Our Ref: WA/61/20/NMA

Non Material amendment following grant of WA/37/20/HH to move location of new, detached garage further away from site West boundary

Bronlea The Street Walberton BN18 0PG

DRAWING TITLE
**Location & Block Plan
PLANNING ISSUE**

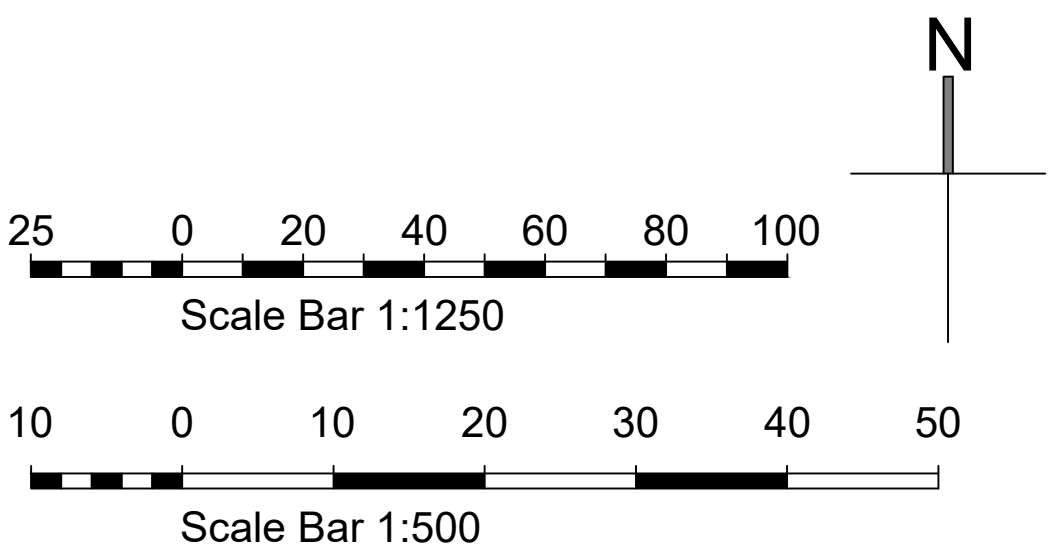
I refer to your recent application for a Non Material Minor Amendment. I note that you seek to move the proposed garage further from the Western boundary of the application site.

Please note than plan reference 'Location & Block Plan - Planning Issue - 20002 - 3.06 - 23.09.2020' now supersedes 'Location and Block Plan - 20002 - 2.00 - Rev. A - 05.03.2020'.
